Your Ref:
Our Ref: PREA/23/00092
Contact: Camila Bastidas

Proposal: Balcony enlargement at 1st floor level with an attached extension to the south east front elevation (to be used as a residential garage), fenestration amendments and ground floor layout changes.
Location: 40 Clifton Road, Poole, BH14 9PP

Client	Mr and Mrs J. Parker		
Location	40 Clifton Road Poole BH14 9PP		
Project Stage	Householder Application		
Scale	1:100 @ A3	Date	21st Jan 2024
Drawing Title	Relationship between 1st Floors 40_40A		
Drawing No.	021	Rev

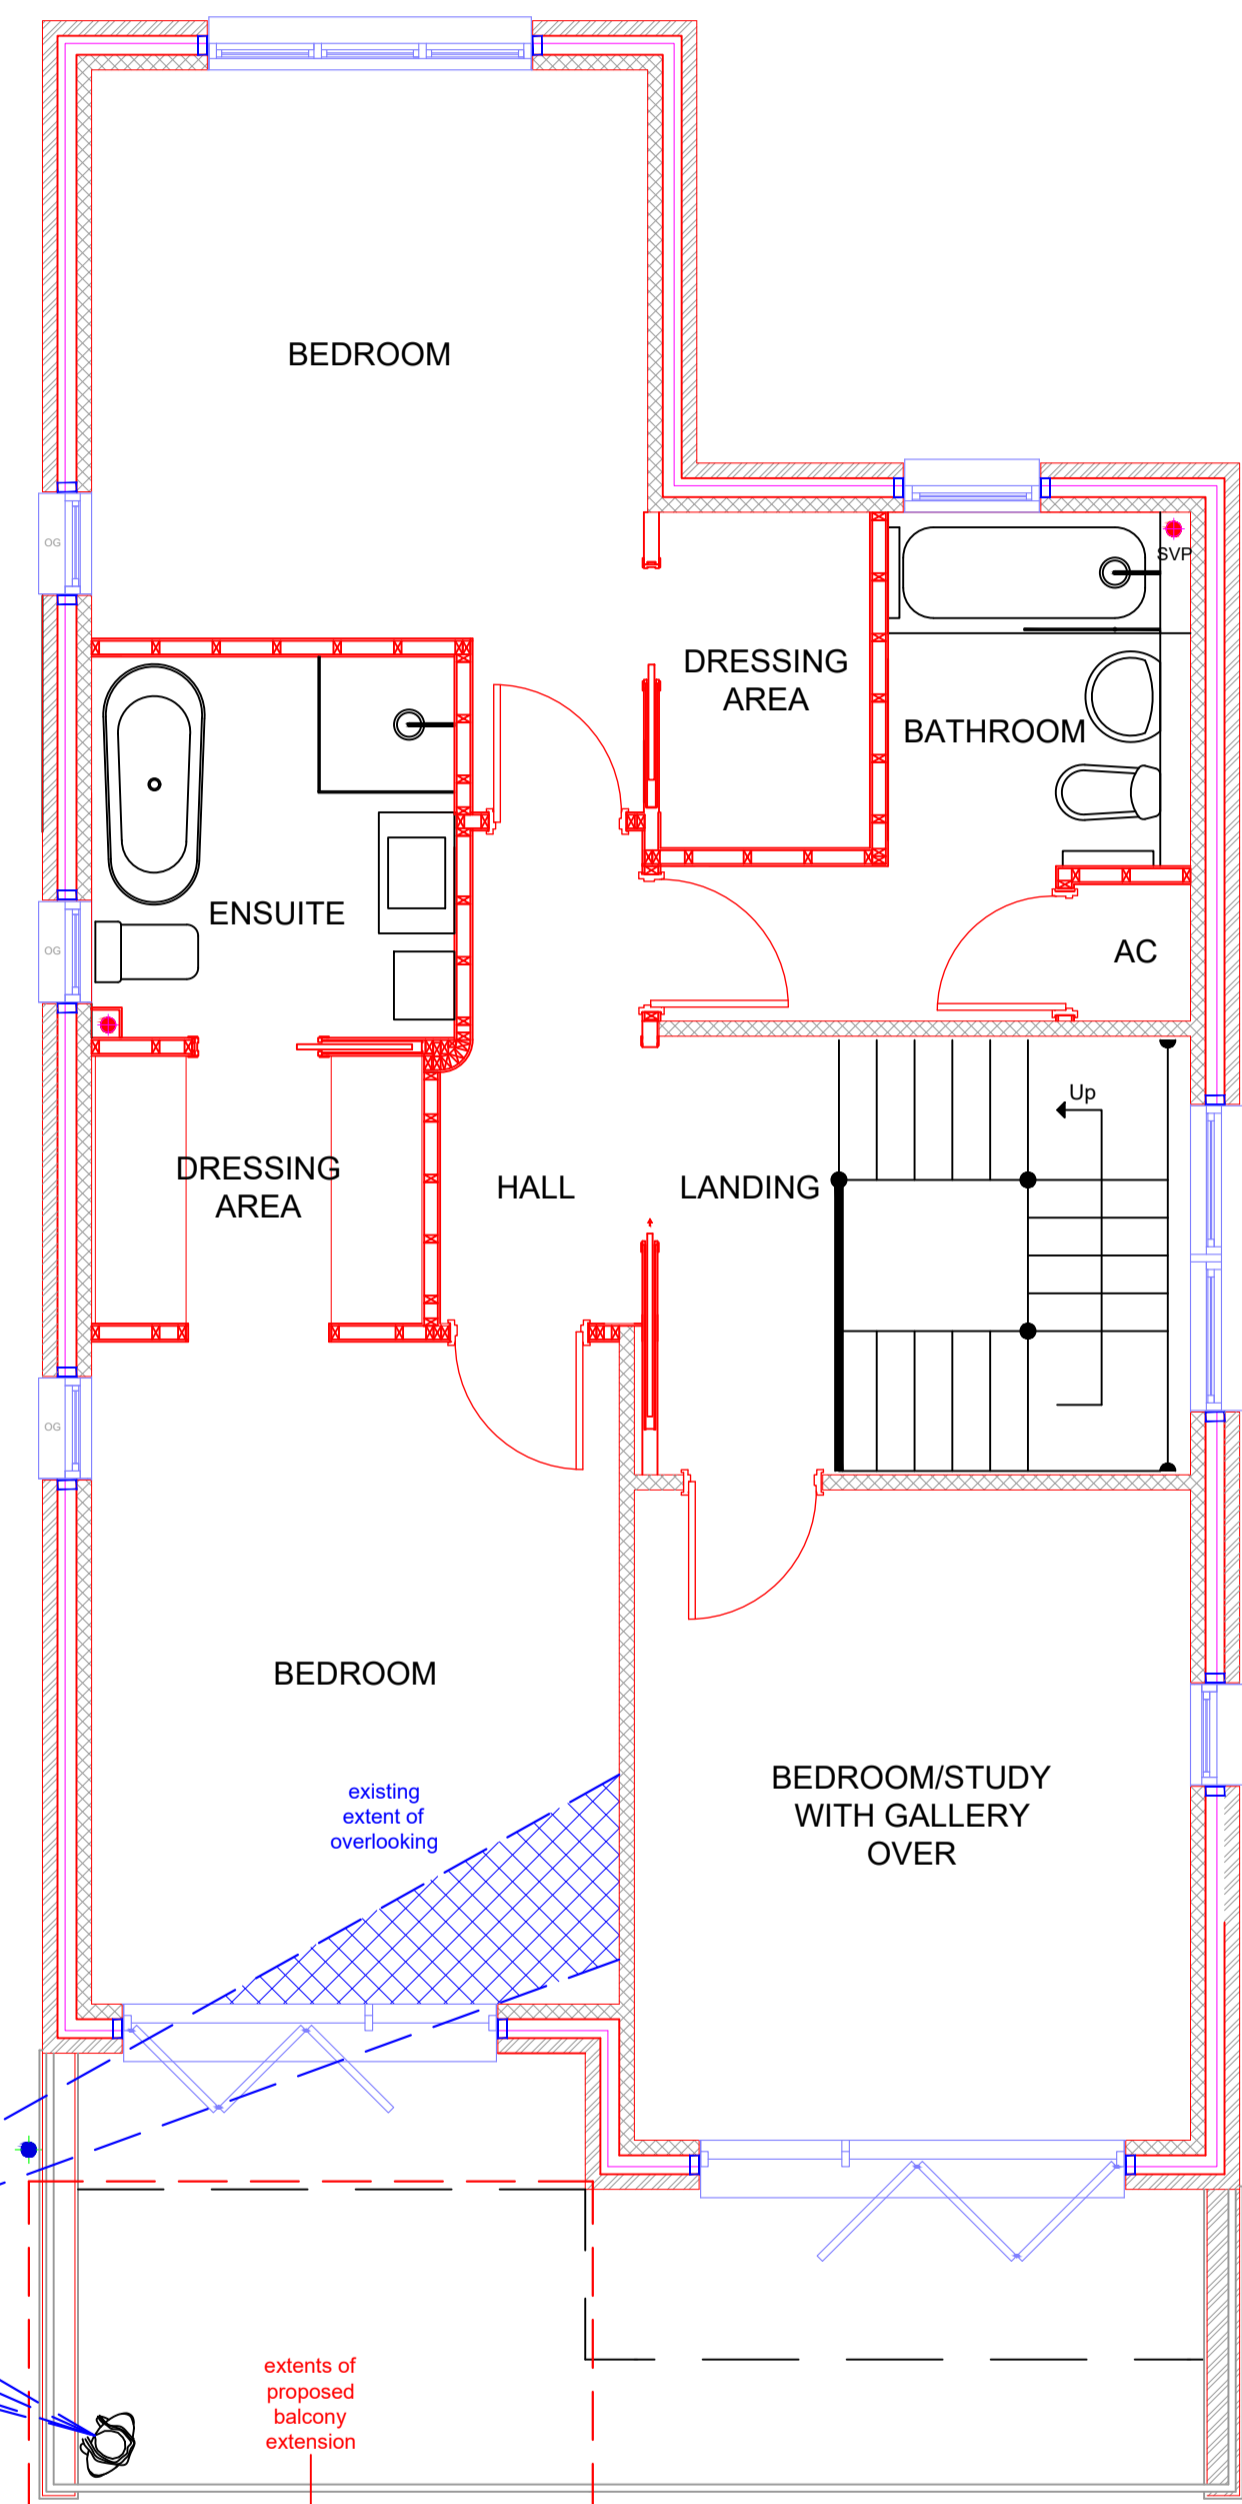
The proposed balcony would most likely allow direct views to the first-floor windows of No. 41 Clifton Road, therefore it would be recommended to insert a privacy screen to the westside of the proposed balcony. However, the proposed balcony enlargement would not materially alter the amenities of the neighbouring dwellings in terms of loss of outlook, daylight/sunlight or have an overbearing impact. It would also not raise harm to the privacy of the neighbouring dwellings.

Therefore, with amendments to the proposed balcony enlargement, the scheme would be considered to be in accordance with Policy PP27 of the Local Plan.
